Application for Removal or Variation of a Condition following Grant of Planning Permission or Listed Building Consent

Erection of a single storey and 2 storey extensions, removal of internal wall, conversion of garage and installation of replacement windows, external doors and rainwater goods and external landscaping

21/0941/LBC

Response to planning for Simon Forshaw

**PROPOSED SITE PLAN** 1:100

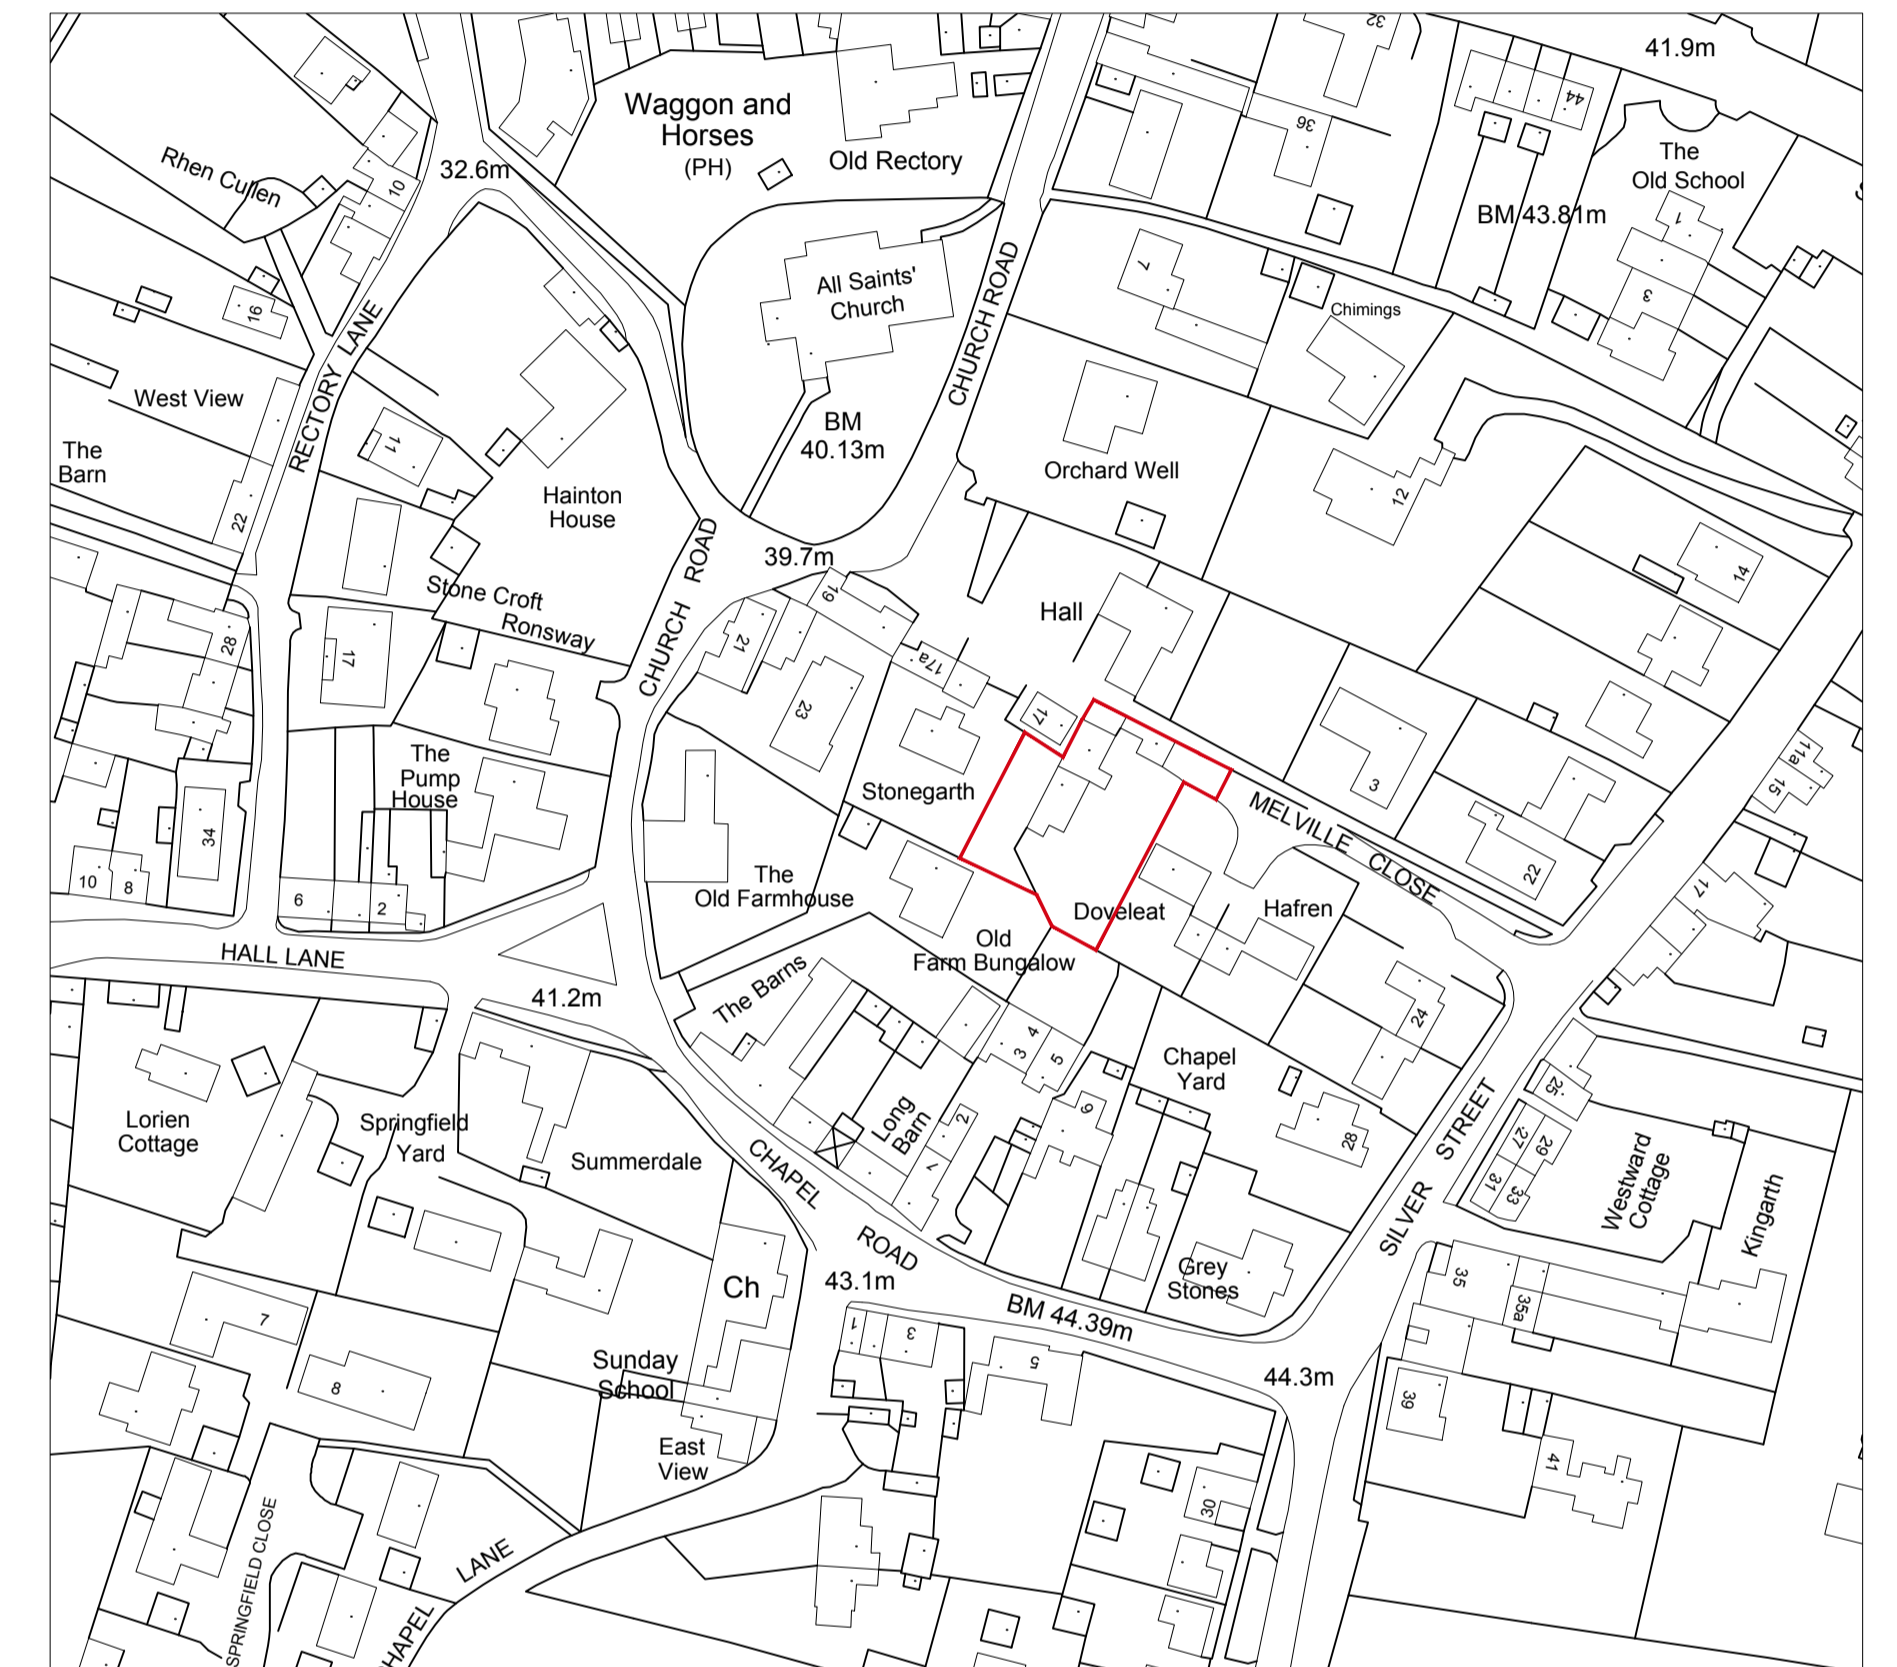
Finally, a shed has been sited at the rear of the orangery within the curtilage of the Listed Building thus does not benefit from permitted development rights. This issue arises once more with the siting/erection of the greenhouse forward of the principal elevation and is also unauthorised. Refer to amended drawings.

Rev	Date	Description	By	Chk'd
01		MR & MRS FORSHAW		
Project: 4 Melville Close, Branston, Lincoln, LN4 1UB				
Drawing Title: PROPOSED PLANS, ELEVATIONS				
Scale: 1:100 @ A1		Date: MARCH 2024		
Job No: 1689	Drawing No: UKSD-SA-08-0002	Revision No: A.00(a)

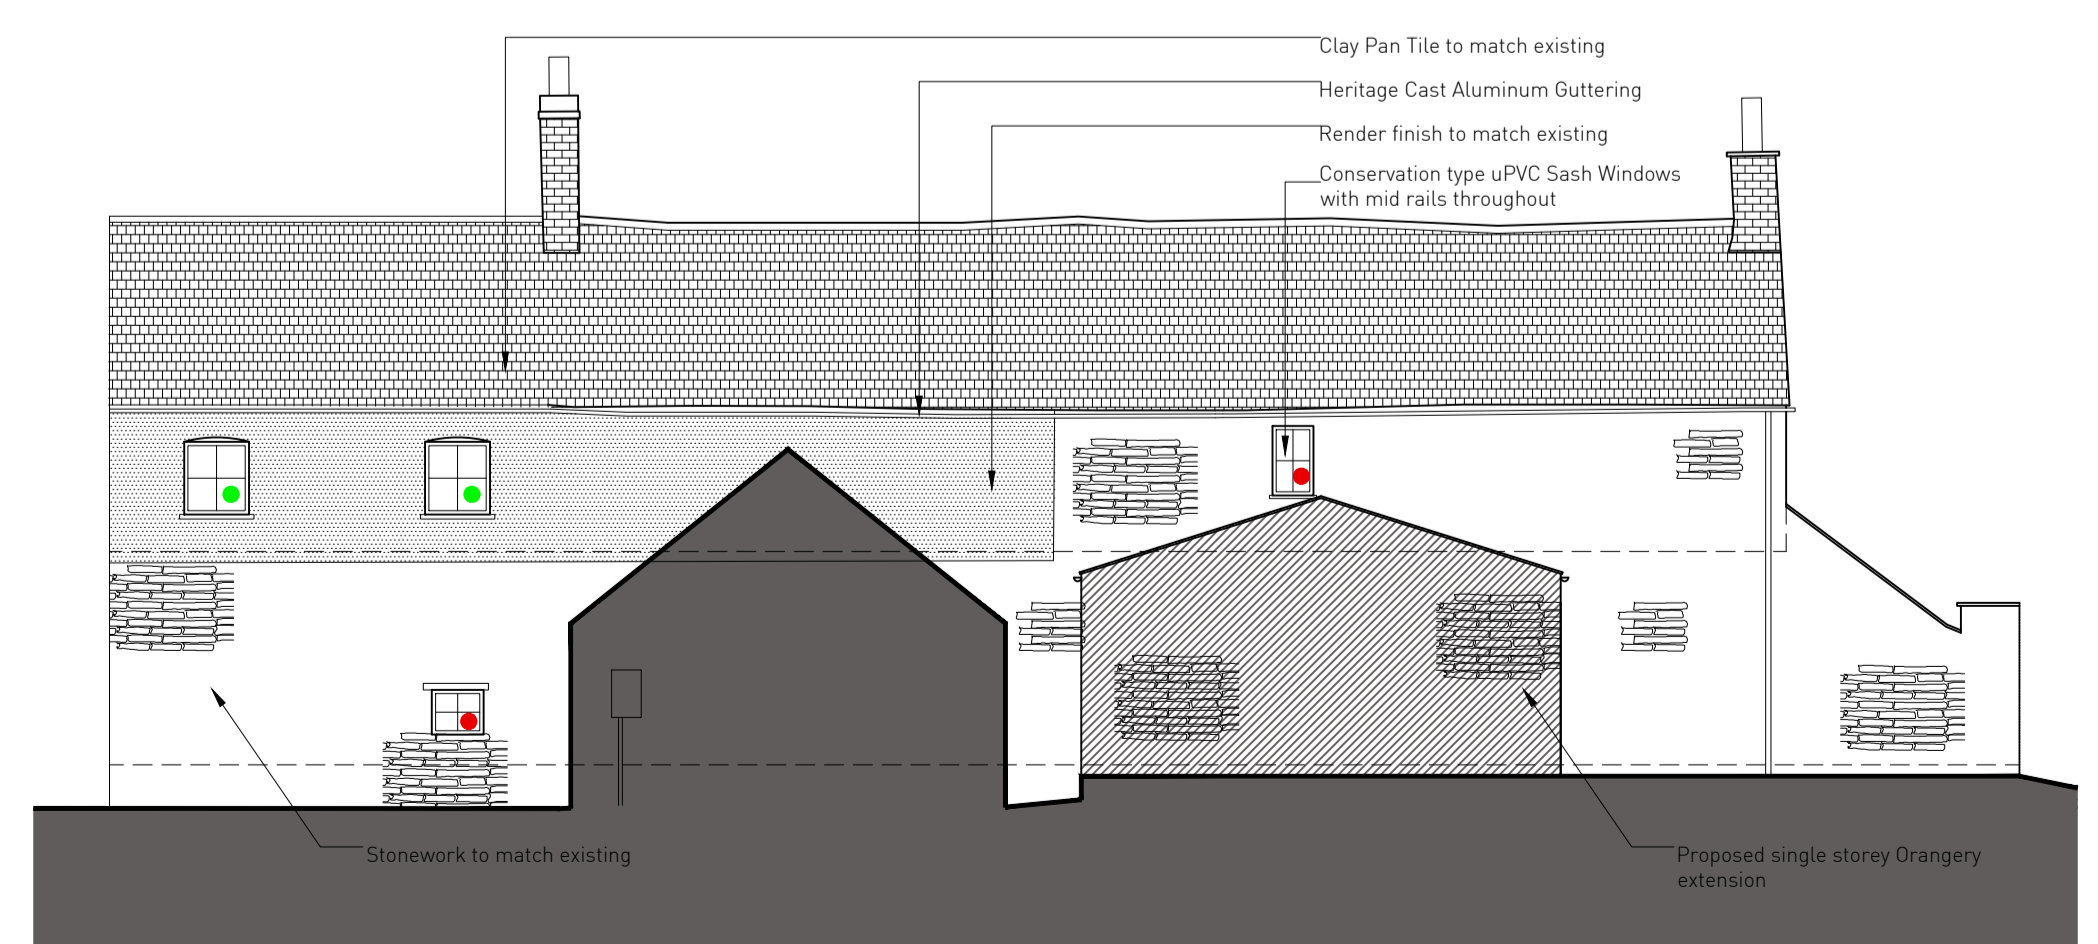
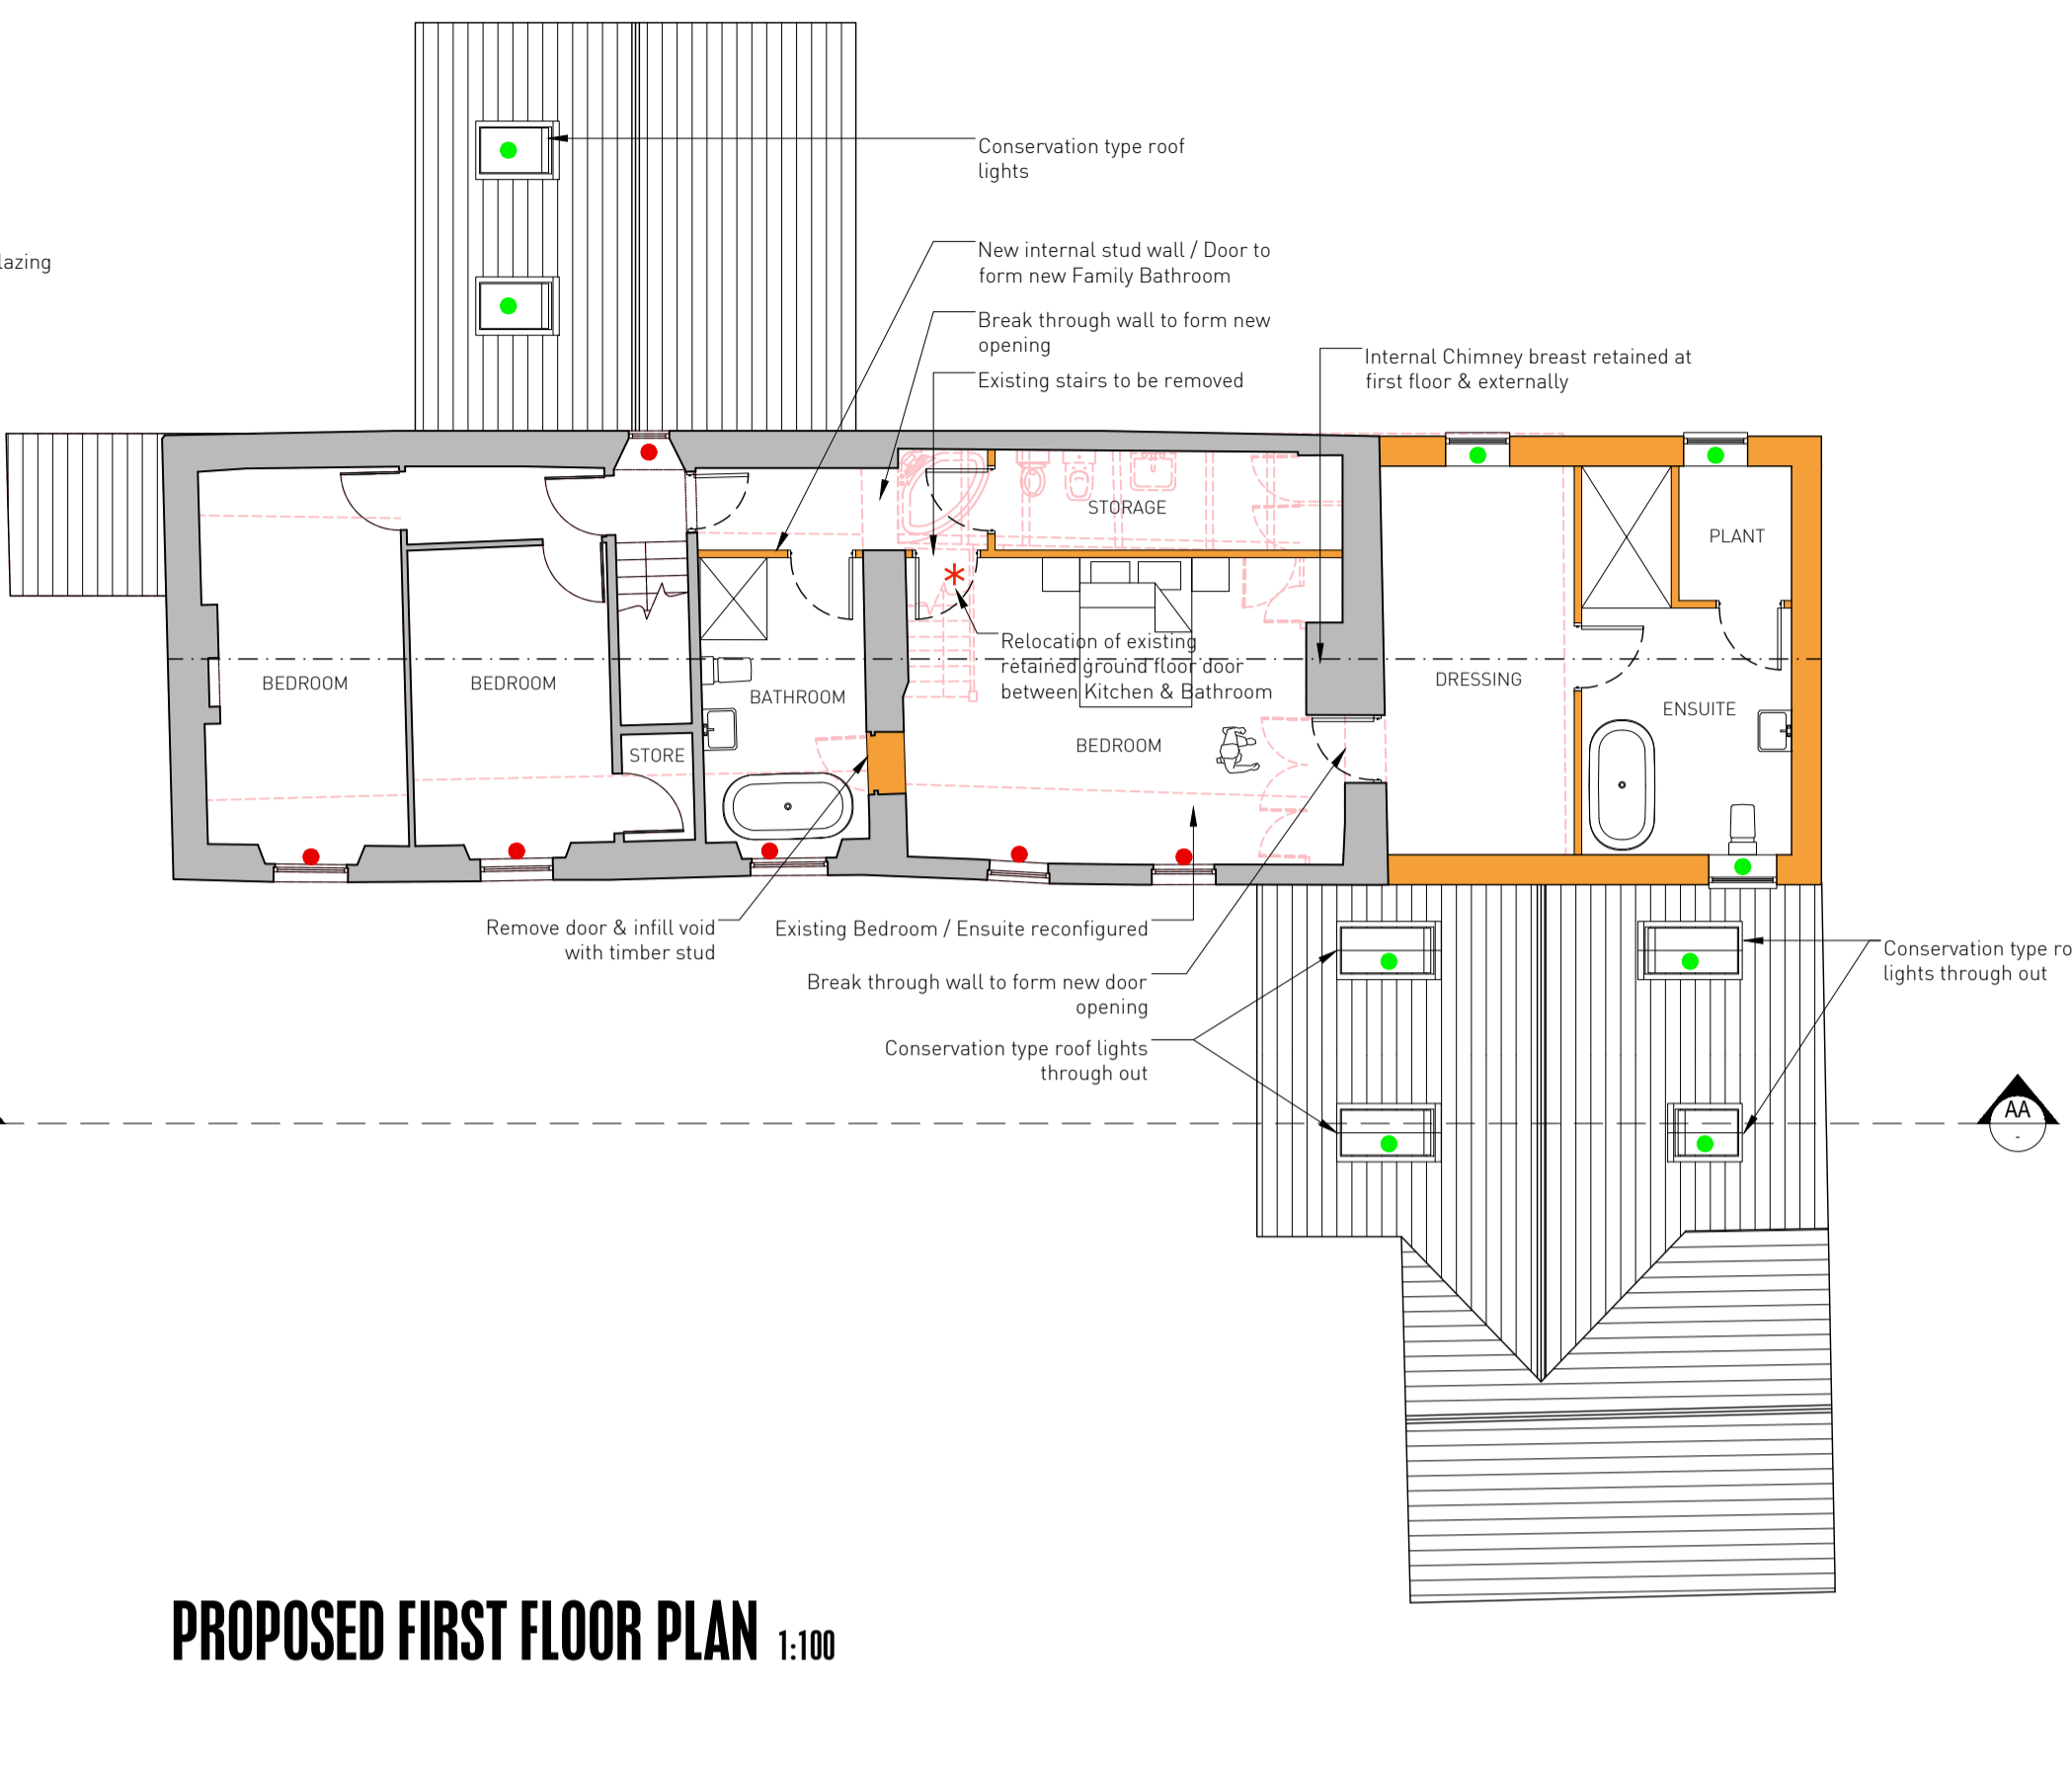
A 1st floor window on rear elevation, not shown on the approved plans, has been installed. Window in question is indicated on the approved drawings.

The faux garage doors have not been installed; instead, the apertures have been partially infilled with the intention of windows being installed in their place contrary to the approved plans. Refer to amended drawings.

The external windows and roof lights of the orangery are not in accordance with the approved plans. Drawings show 5 windows and 5 connected roof lights above. The development was found to have 4 windows and 2 separate conservation type roof lights. Refer to amended drawings.

The roof line of the garage and front connecting single storey extension are not in accordance with the approved plans. From inspecting the plans and consulting a resident joiner, it is clear that due to the different roof pitches the valleys will not marry up and the plans cannot be built out correctly. This statement is supported by what has been seen as built on site. Refer to amended drawings.
